Our ref: SSD-9835-PA-158

**Sydney Football Stadium Redevelopment (SSD-9835)
Event Noise Monitoring Reports (Elton John and Bruno Mars), Conditions E9 and E10**

I refer to the Event Noise Monitoring Reports (noise reports) prepared for the Elton John and Bruno Mars concerts in accordance with condition E9, and submitted to the Planning Secretary under condition E10 of SSD-9835.

Figure 5: Noise monitor locations - plan view

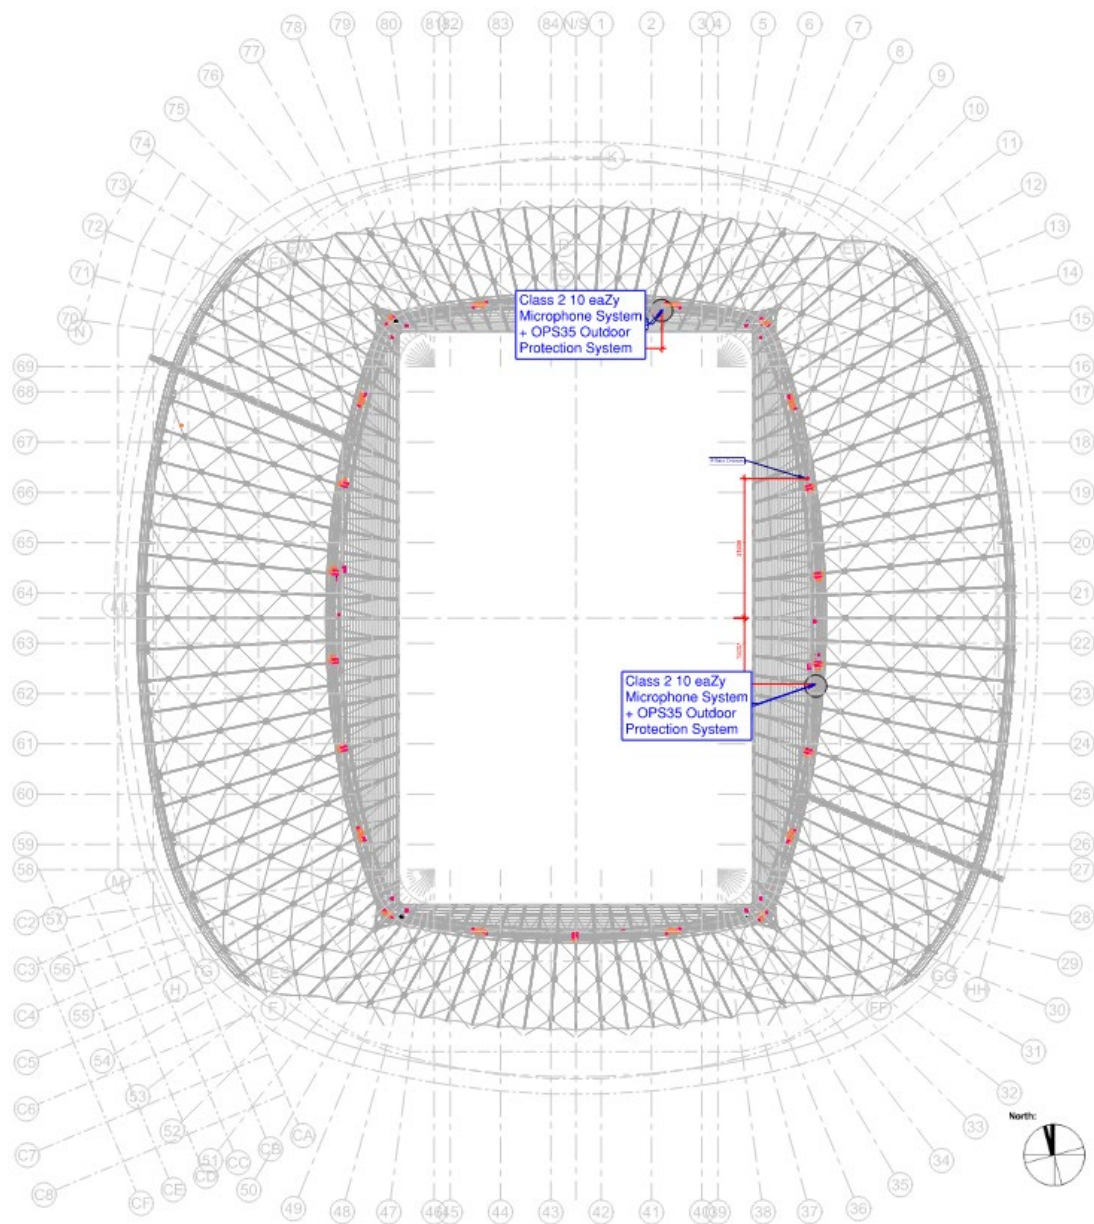
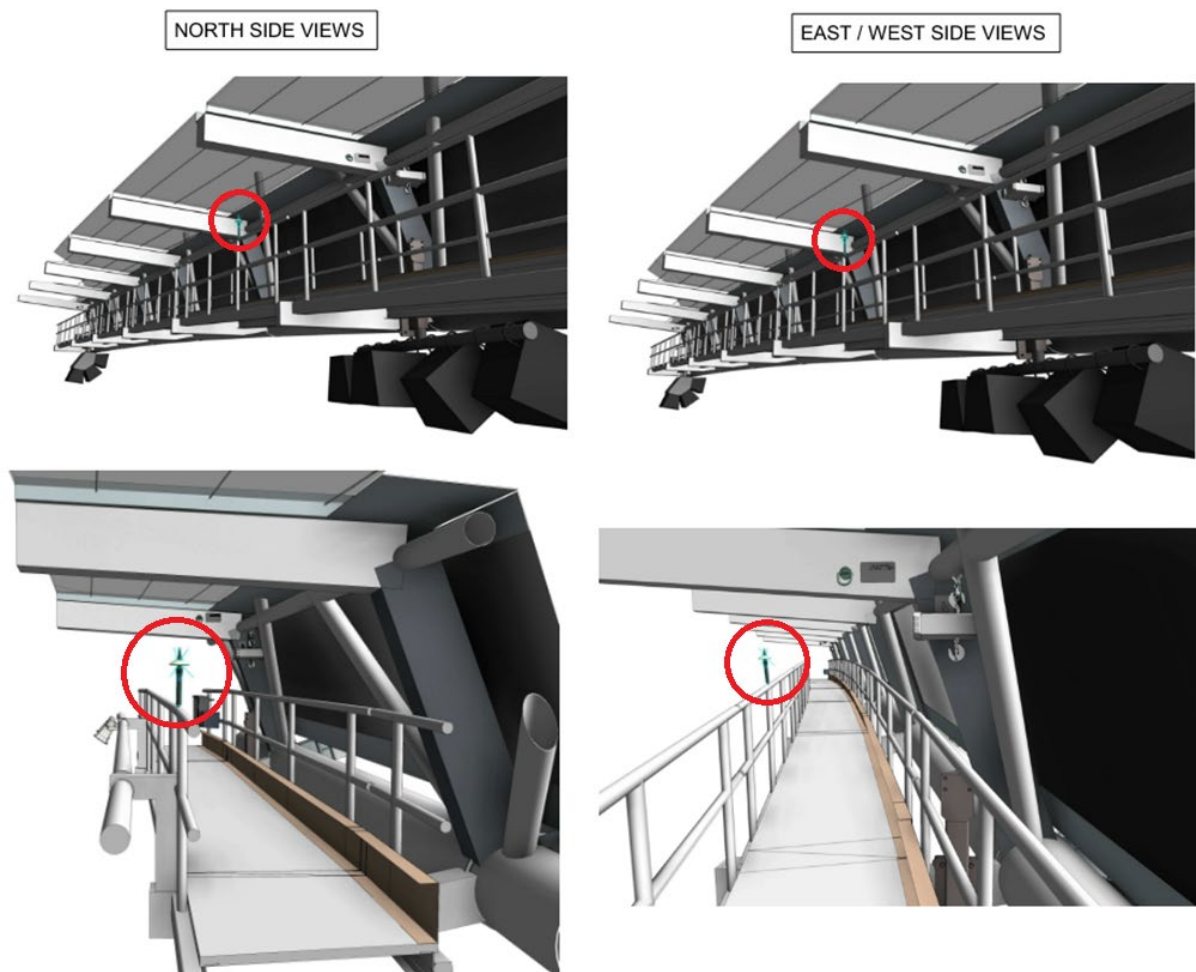
Condition	Planning Secretary's written advice
	noise data was used / will be used to inform the setting of noise level triggers for the stadium microphones to ensure compliance with noise limits. Section 6 of the noise report states that once transfer functions were derived, they were "... then applied to the PNMS to establish concert noise limits for the sound system within SFS ..." These are considered to be the noise level triggers for the PNMS microphones referenced in this condition. However, PNMS trigger levels were not provided in the noise report, only transfer functions. It is necessary to identify the trigger levels in the additional noise report required under the Planning Secretary's Direction, to ensure compliance with noise limits. <u>Conclusion 3a</u> VNSW must identify the PNMS trigger levels for the northern and eastern PNMS microphones in the additional noise report required under the Planning Secretary's Direction. <u>Conclusion 3b</u> VNSW must establish transfer functions between the eastern PNMS microphone and 5 Poate St in future. To effect this, the ONMP must be updated to require transfer functions being established between the northern microphone and 252 Moore Park Rd, and between the eastern microphone and 5 Poate St, where the typical north speaker facing south configuration is adopted. <u>Conclusion 3c</u> VNSW must provide PNMS corrected data for 5 Poate St from the eastern PNMS microphone in the additional noise report required under the Planning Secretary's Direction.
